**WEST SUSSEX COUNTY COUNCIL
STRATEGIC PLANNING CONSULTATION**

SUBJECT: LU/234/16/RES - Application for reserved matters relating to access, appearance, landscaping, layout and scale of the previously approved LU/63/11/. This application affects a Public Right of Way.

LOCATION: Fitzalan Link Road, Worthing Rd (A259), East Street, Littlehampton, West Sussex.

AB 30/11/16 - Mayer Brown Response to WSCC comments dated 21 November 2016.

rev.
P5

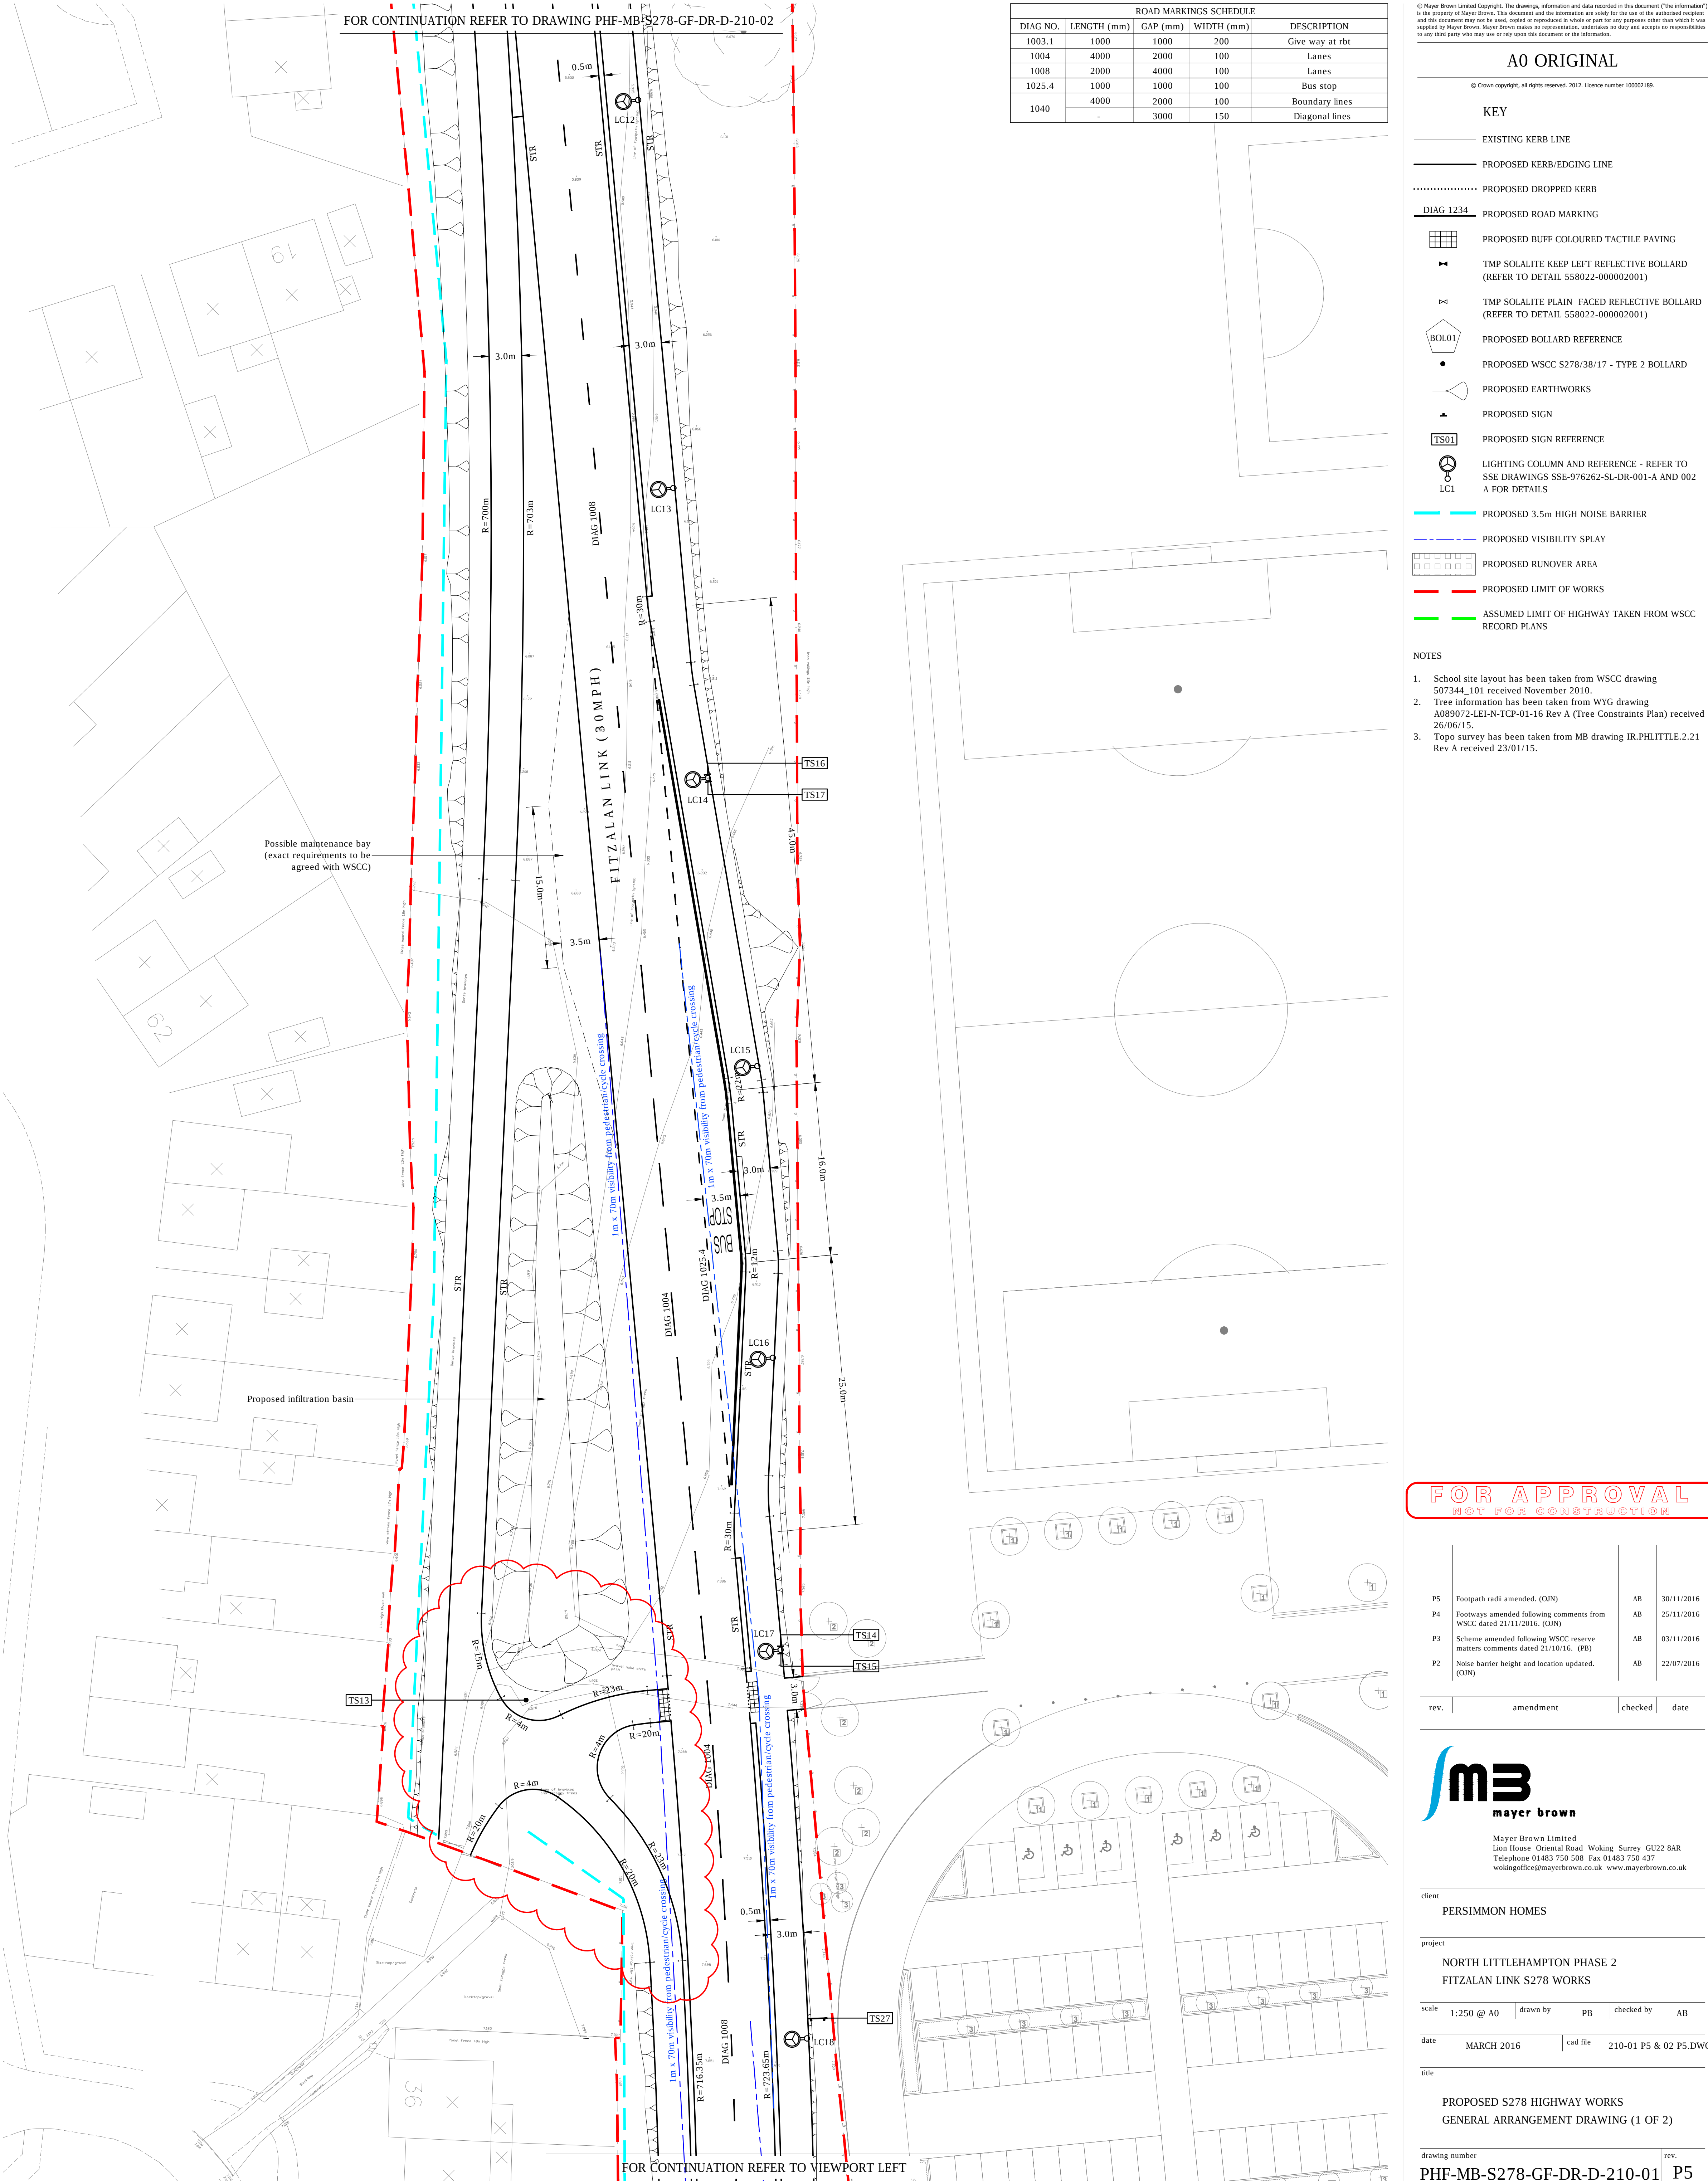
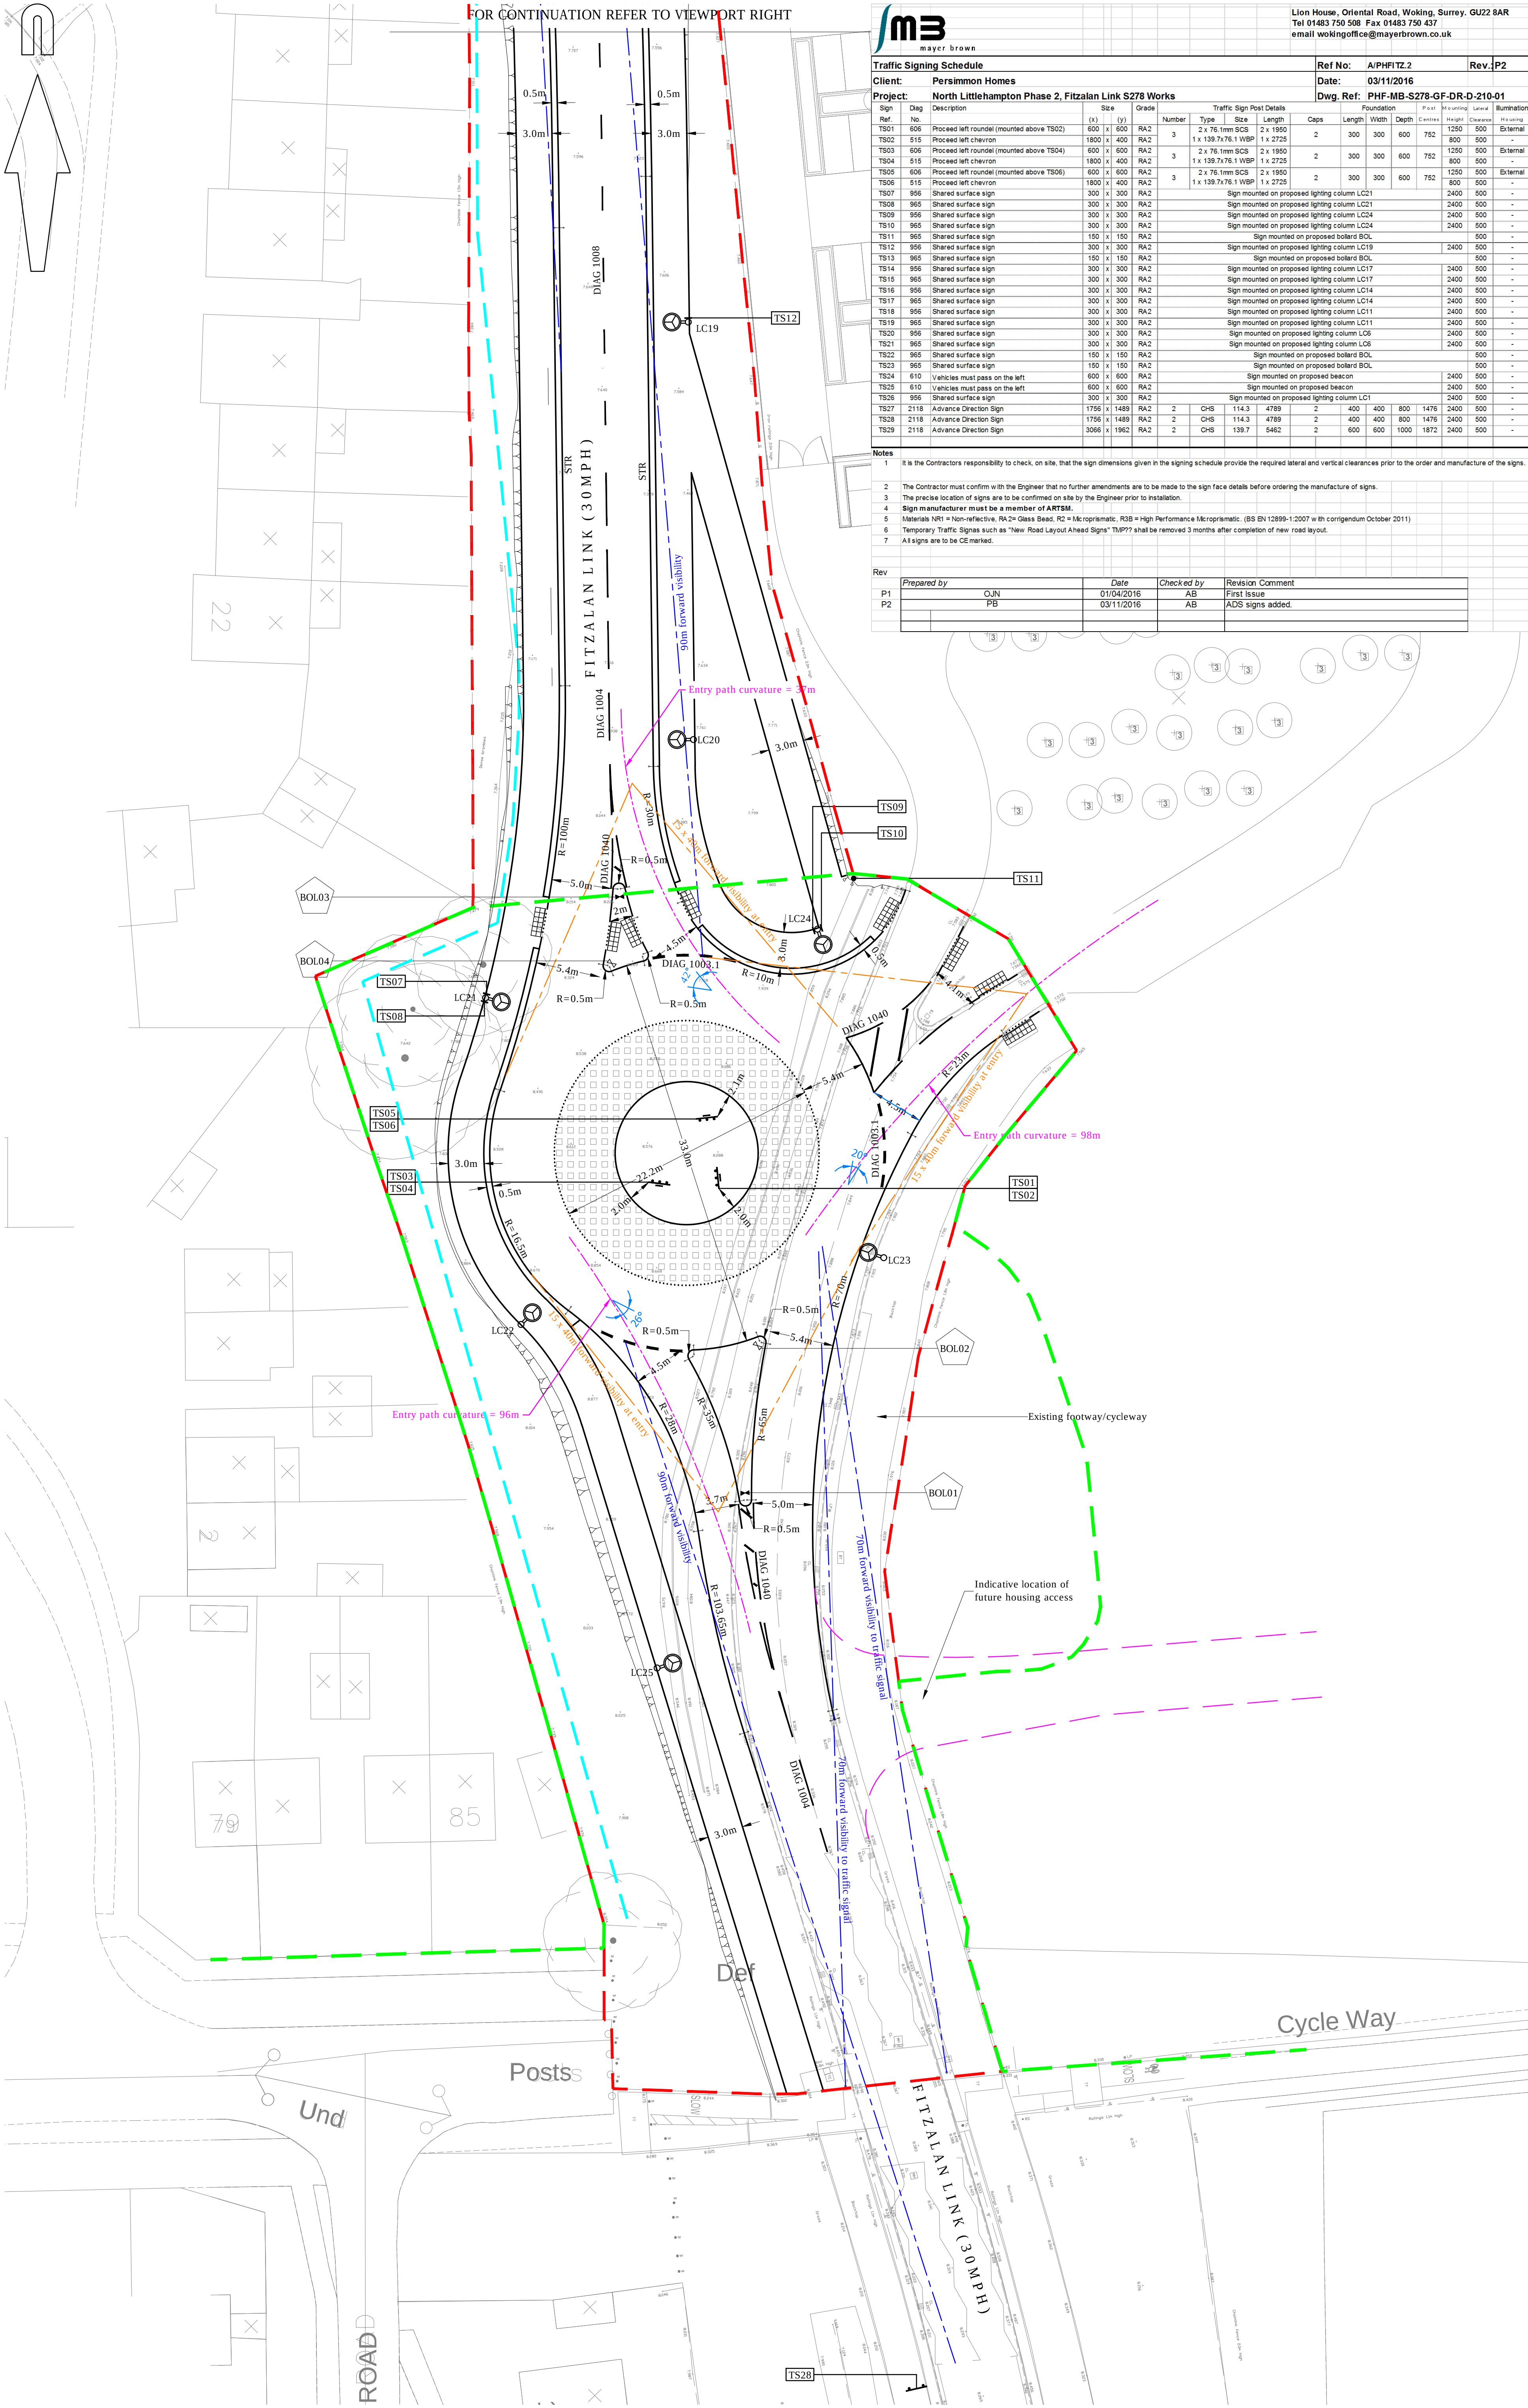
4. Refuge adjacent to Highdown Drive – Applicant should demonstrate that adequate kerb-to-kerb width for vehicles is provided either side of the proposed pedestrian/cycle refuge and that the refuge itself is wide enough for pedestrian and cycle usage. The full WSCC specification for refuges can be found on the WSCC website. **Further information and alterations required.**

5. Shared footpath/cycleway on south-eastern side of the Academy RBT - To be shown remaining as shared footway/cyclepath – NOT landscaping as shown on one of the landscaping plans. **Further information and alterations required.**

9. Street lighting considerations – what is proposed? **Further information required.**

10. Maintenance access and access routes to be identified alongside road (to permit vehicles to be parked clear of the road when maintenance is taking place) – Please show.

Accepted. The design has been amended to incorporate a pedestrian refuge island as required by WSCC detail numbered S278/38/19 Rev B with 3.2m lane widths, 2.5m wide island and road markings offset from the island, as requested. Please refer to amended drawings PHF-MB-S278-GF-DR-D-210-02 Rev P5.

Accepted. The existing footway/cyclepath has been shown as retained on amended drawings PHF-MB-S278-GF-DR-D-210-01 Rev P5 and the updated landscaping plans prepared by WYG.

Noted. The street lighting design has been prepared by SSE and is indicated on the MB general arrangement drawings PHF-MB-S278-GF-DR-D-210-01 Rev P5 and PHF-MB-S278-GF-DR-D-210-02 Rev P5. The proposed SSE specification is:

Noted. I'm sure this will be discussed in greater detail during the detailed technical approval stage. However, a maintenance bay has been included within the scheme, north of the Academy roundabout for maintenance vehicles. Please refer to the MB general arrangement drawing PHF-MB-S278-GF-DR-D-210-01 Rev P5.
